KIRKLEES METROPOLITAN COUNCIL INVESTMENT & REGENERATION SERVICE

DELEGATED DECISION TO DETERMINE PLANNING APPLICATIONS

Reference No:	2025/62/92104/W
Site Address:	50, Birkby Lodge Road, Birkby, Huddersfield, HD2 2BG
Description:	Erection of two storey side extension and extension to existing porch (within a Conservation Area)
Recommending Officer:	Joshua Merriman

Officer Report – 2025/92104

CLIENT	Mr Jamil Akhtar		
ADDRESS	50 Birkby Lodge Road HD2 2BG, Huddersfield		
PROJECT	Two Storey Side Extension		
DRAWING	Proposed Layout and Elevations		
DRAWN	UH	DATE	July 25
		SCALE	1.50@A1
DWG No.	2224/04A		
STATUS	PLANNING

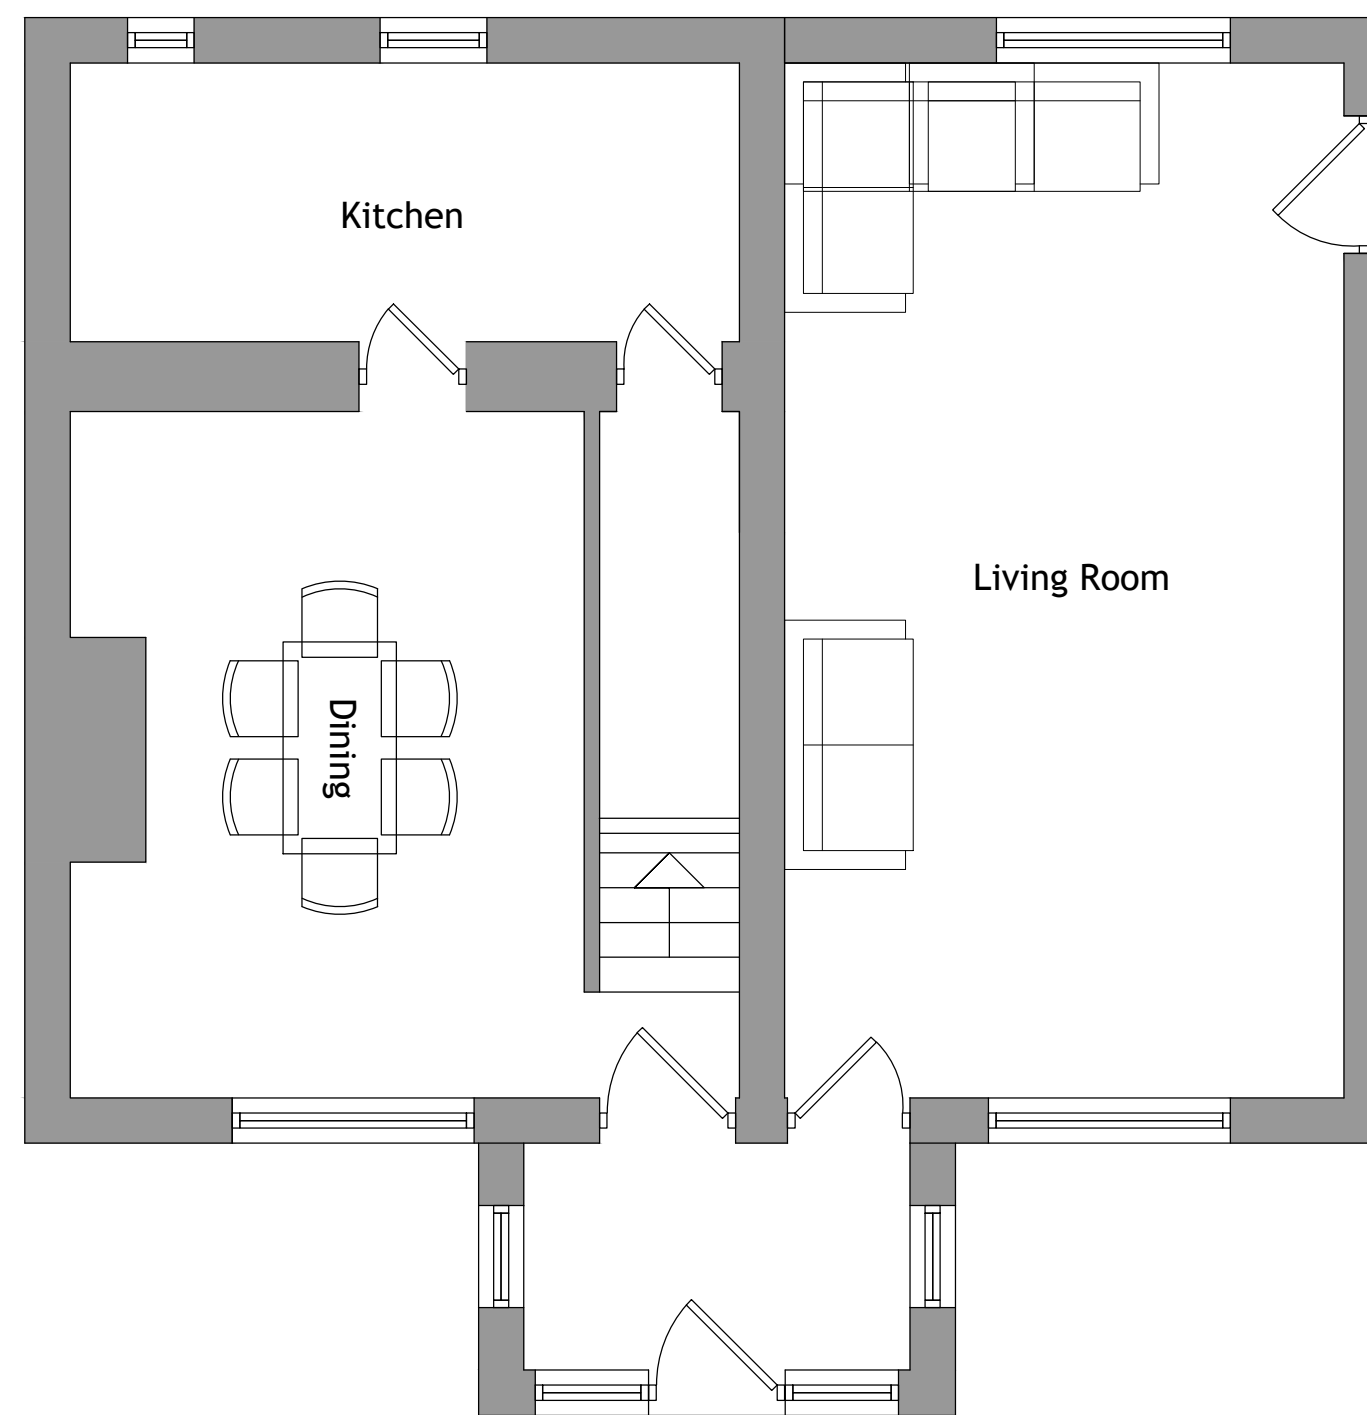
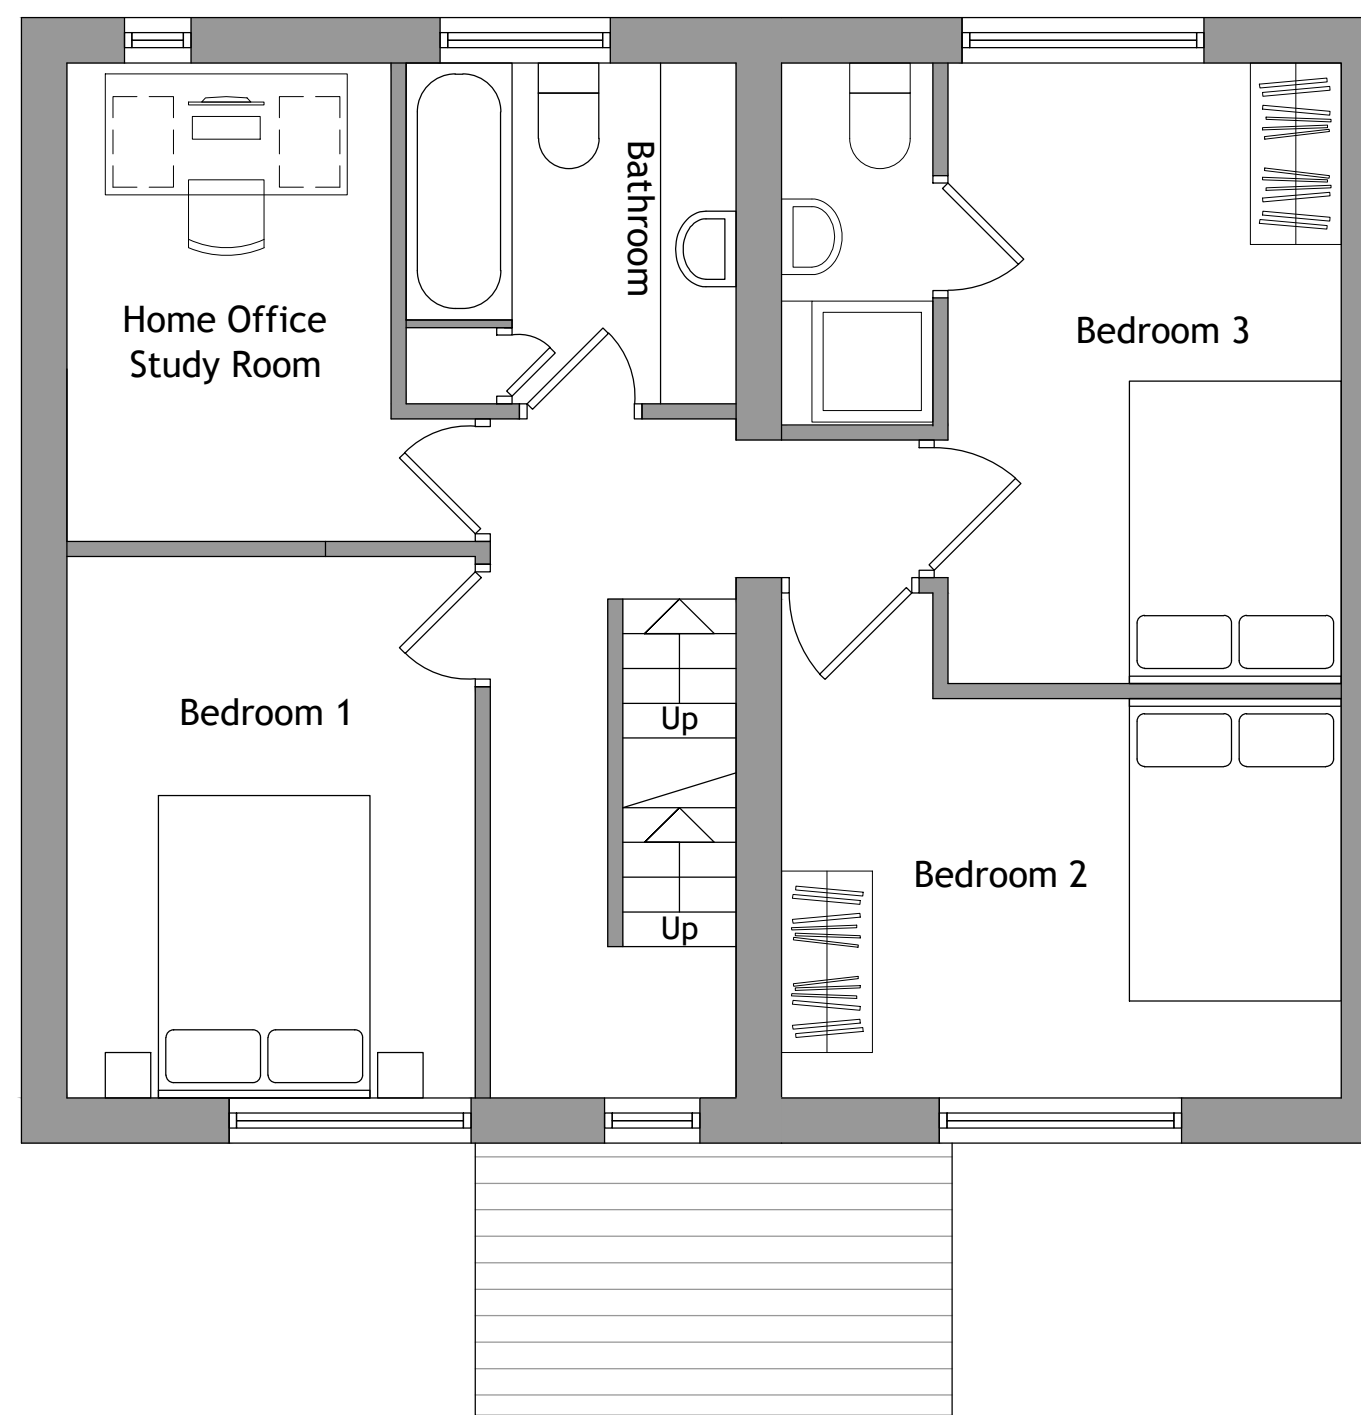
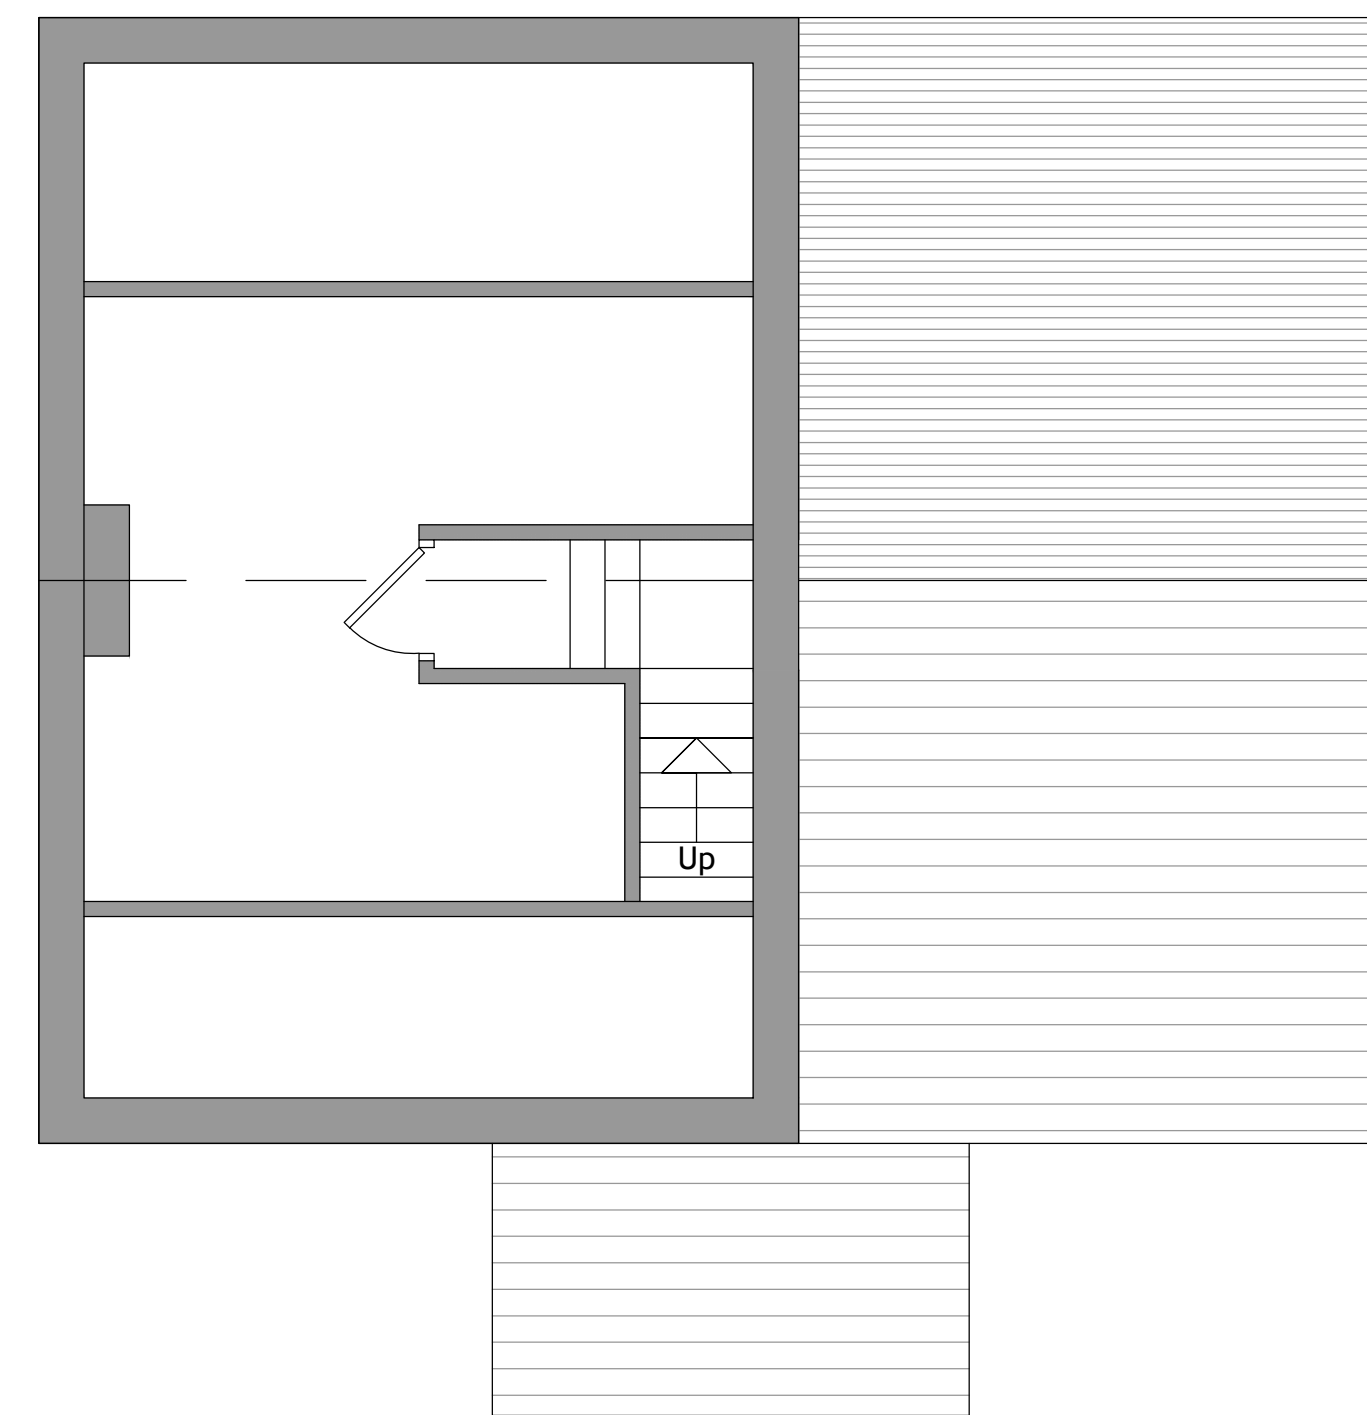
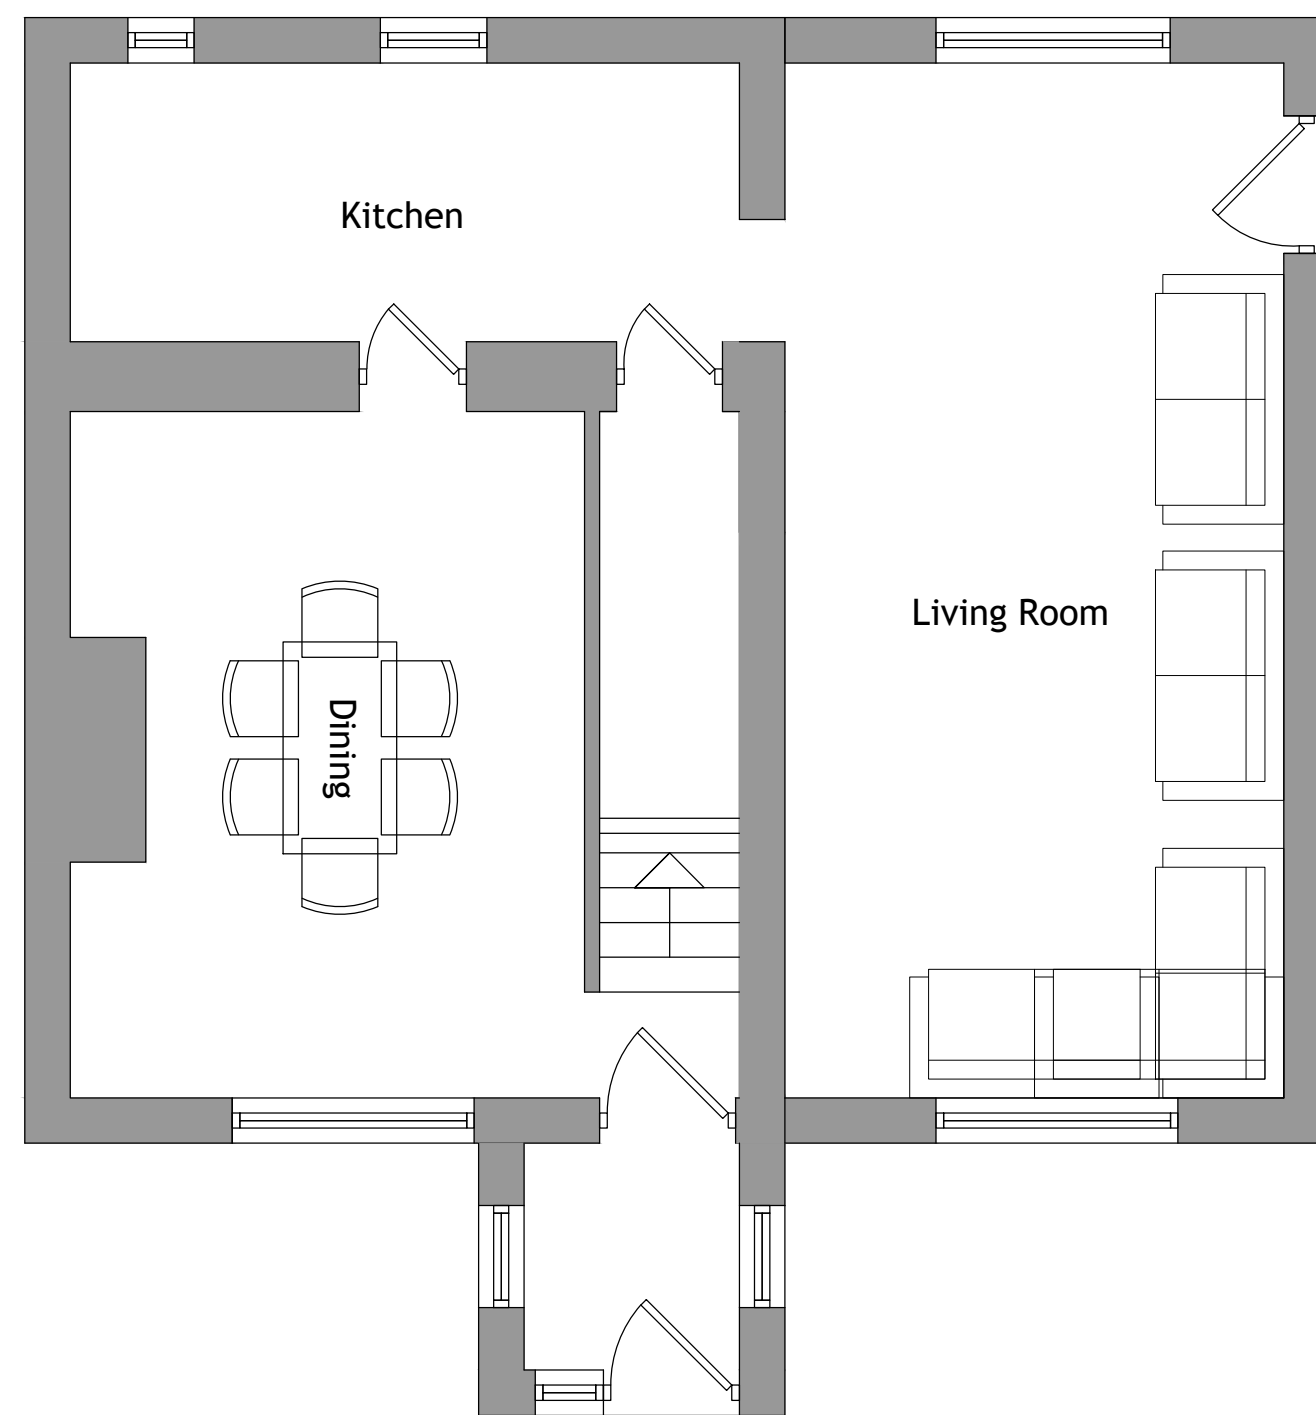
The case officer sought it necessary to set back the side extension and reduce its scale to ensure subservience to the original building, as well as reducing the scale of the front porch so it also remained subservient and only served the original dwelling. Following the receipt of amended plans, it was considered that the development was acceptable.

05/12/2025 – 2224 – 04C Proposed Layout and Elevations
